## Conversation with Deb Andrews, 3/20/2018, re. 415 Cumberland Avenue

**A1.01**

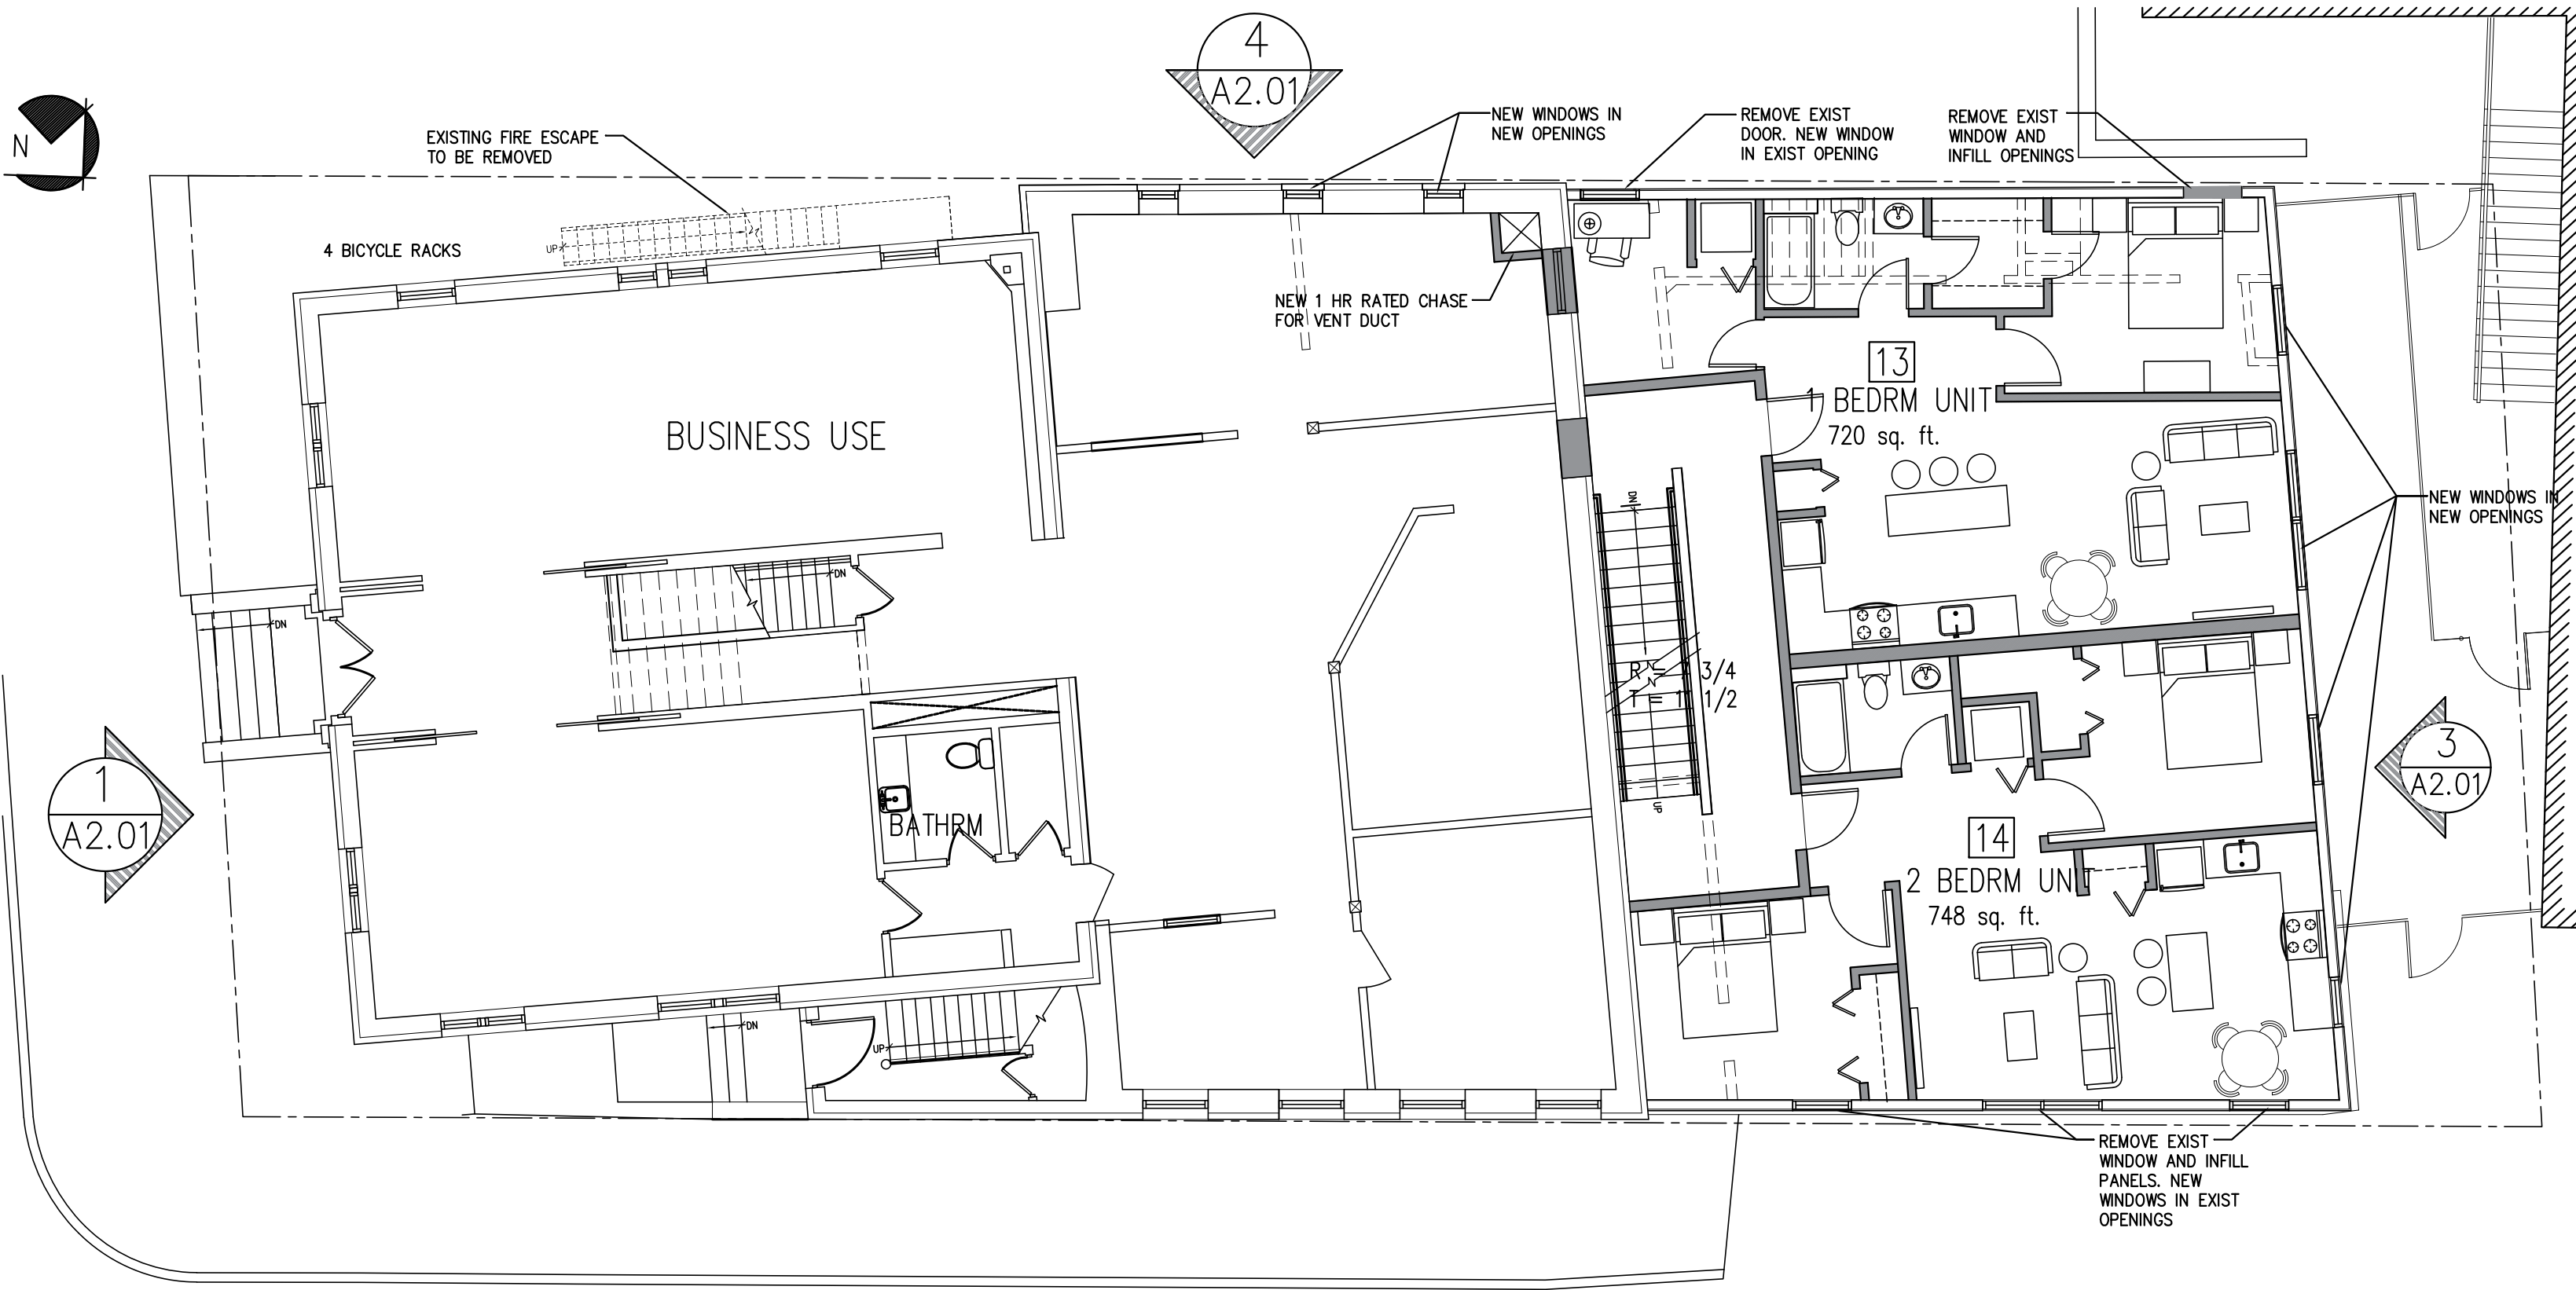
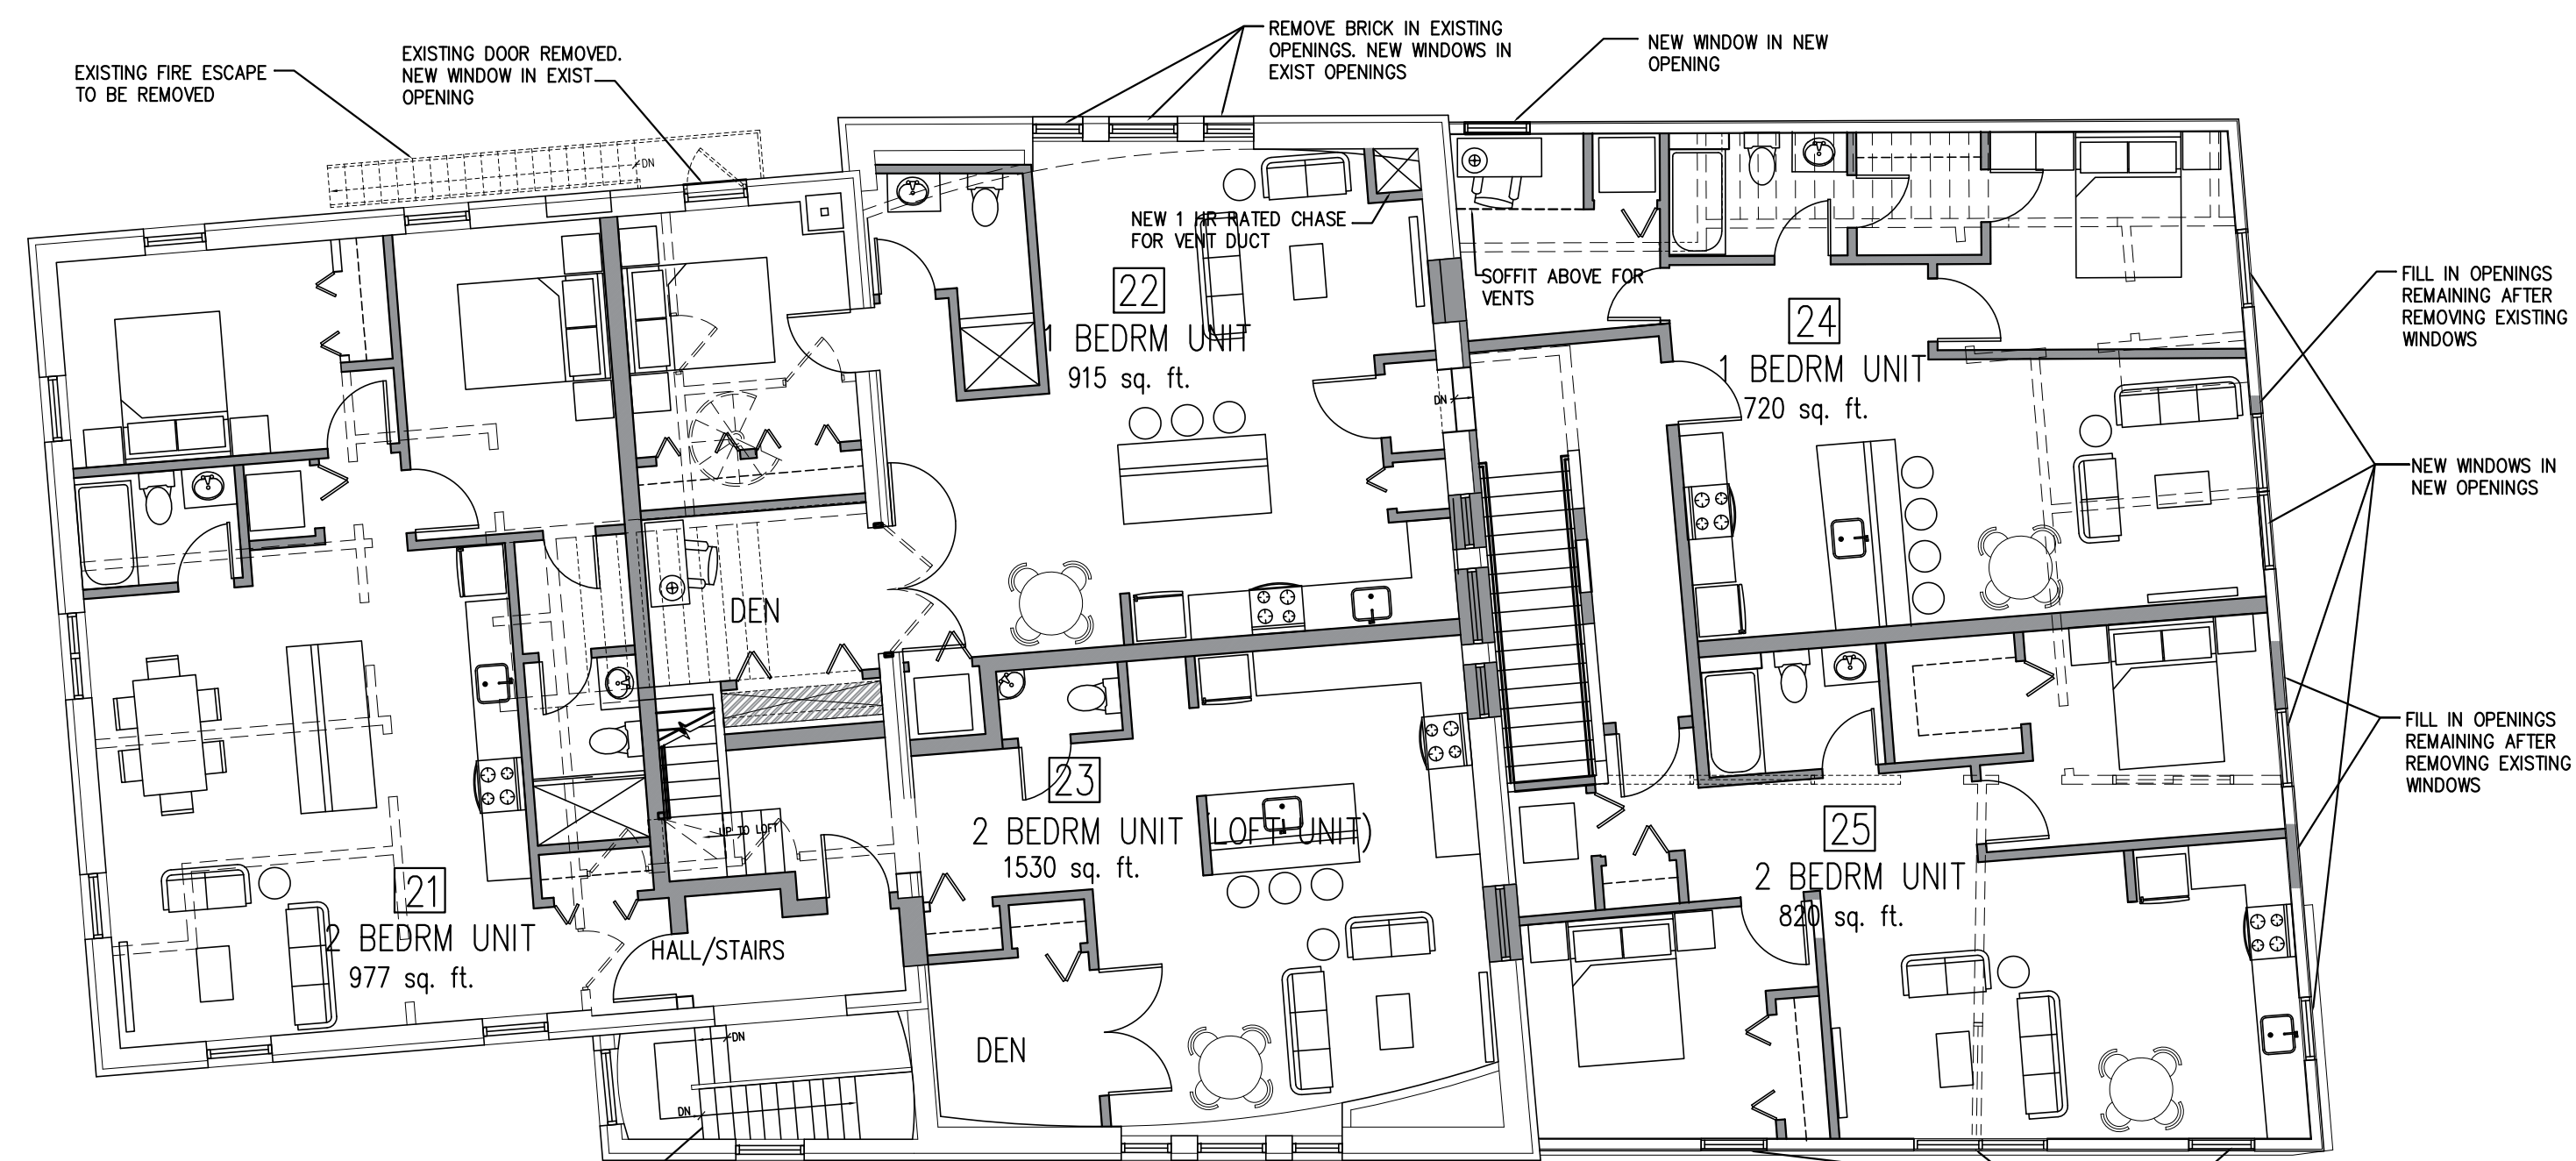
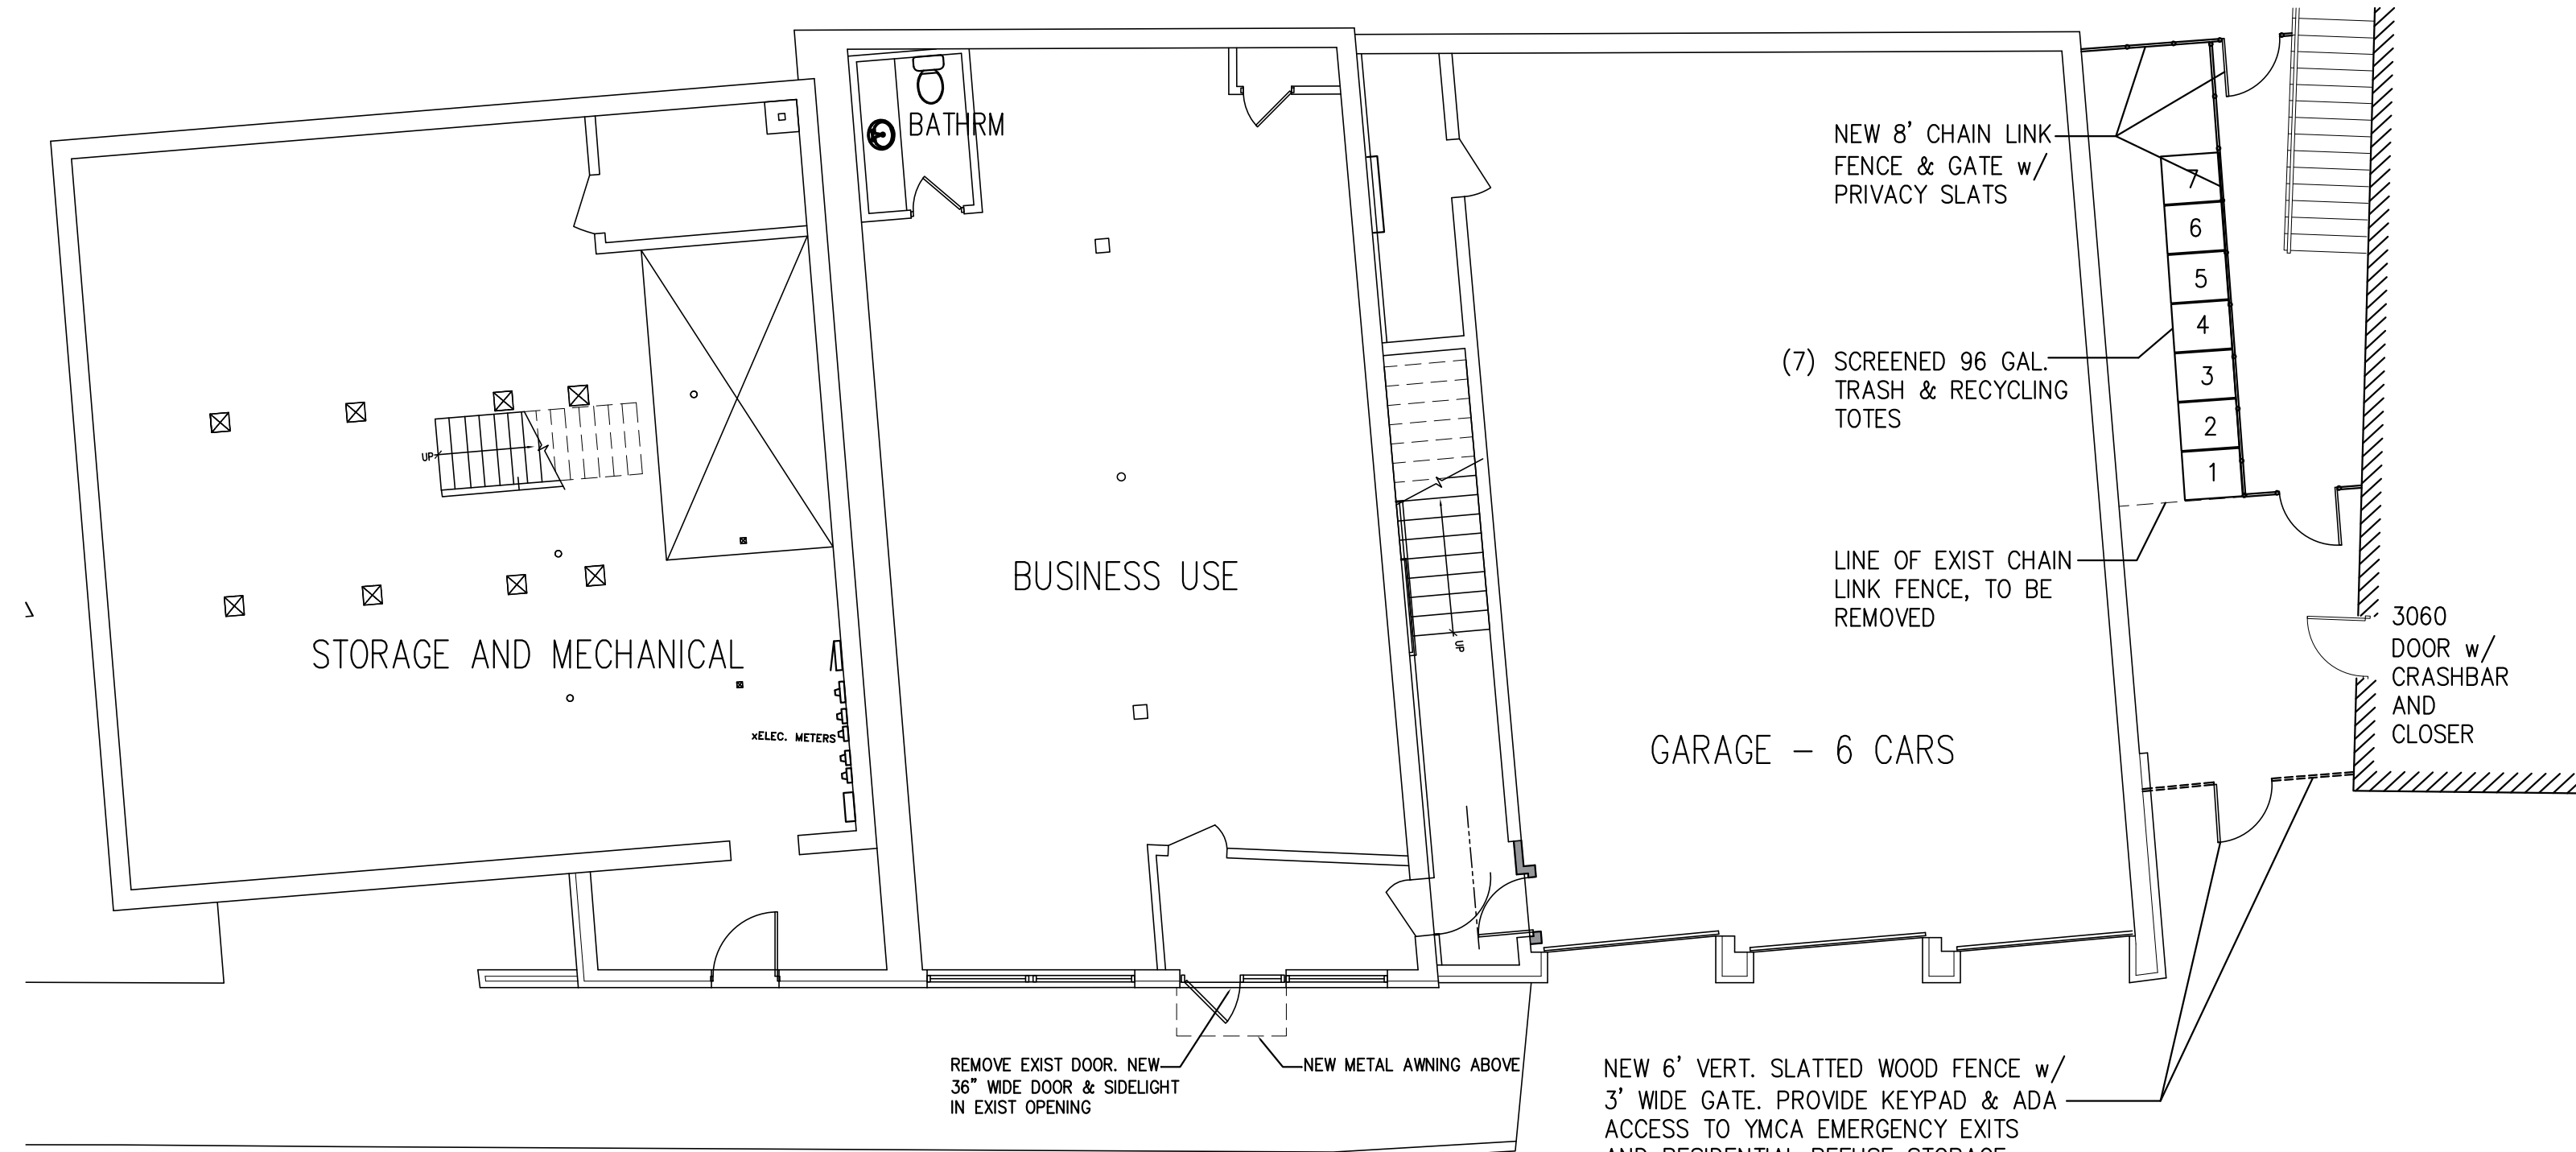
Request clarity / detail regarding the penthouse / mezzanine. What changes are being made, if any, and what materials are being used. Are the proportions of the existing windows changing?
